RESPONSE TO IPC SSD 10371 – TRINITY GRAMMAR SCHOOL

This Letter has been prepared by Willowtree Planning Pty Ltd on behalf of Trinity Grammar School, in relation to SSD 10371, being the State Significant Development Application (SSDA) for the Trinity Grammar School Redevelopment.

Specifically, this Letter is provided in response to the Request for Information (RfI) from the Independent Planning Commission (IPC), dated 16 August 2021 (refer **Appendix 1**). Attachment A of the RfI lists the matters on which an Applicant response has been requested.

01 SECTION
Section BB
Scale 1:200

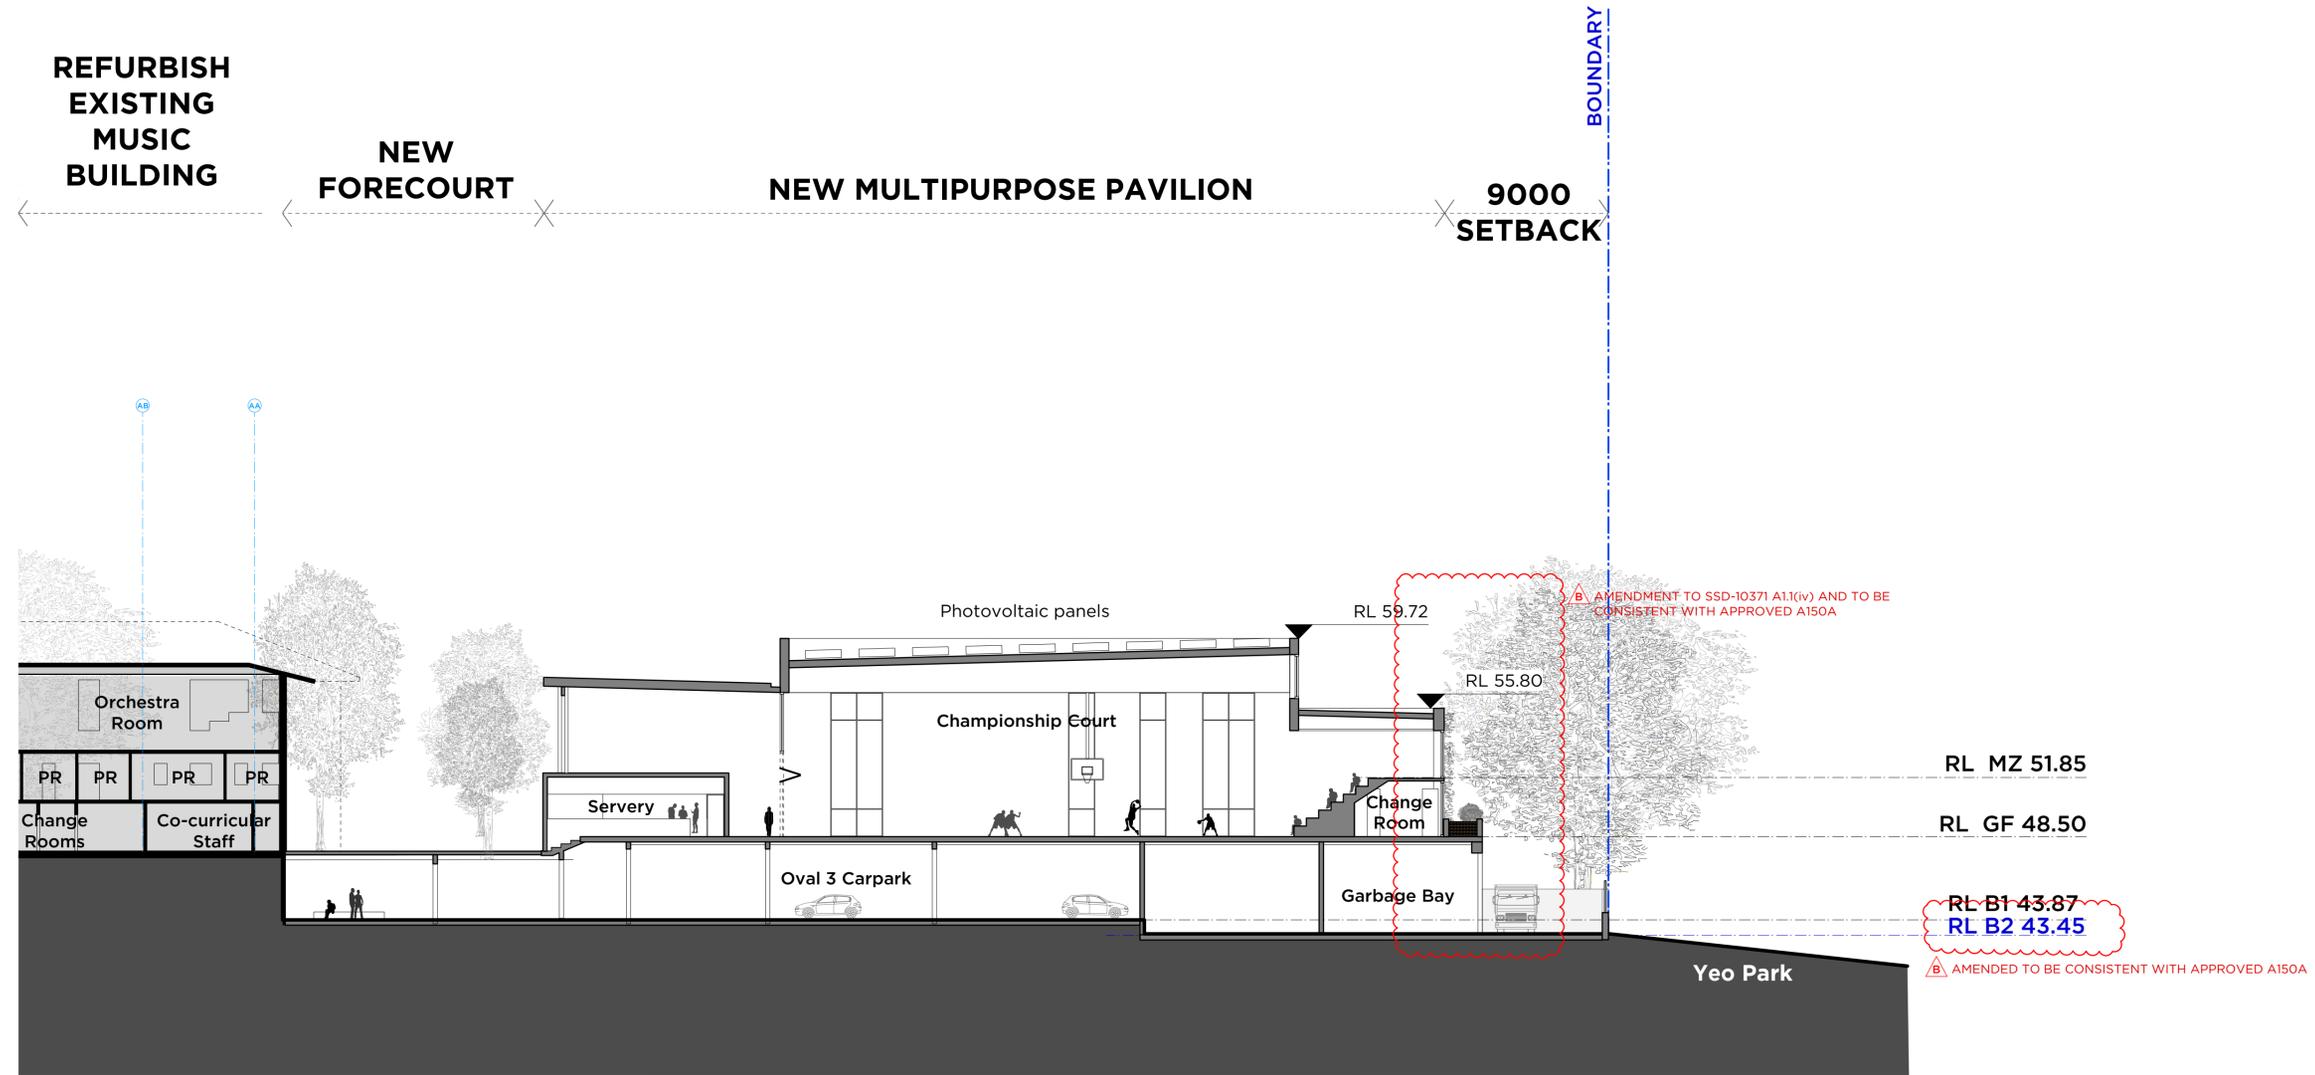
3. Annotated sections through all new buildings (at a scale no less than 1:200) including RLs and dimensions.

Detailed, annotated Architectural Sections are provided within the Architectural Drawings at **Appendix 2**.
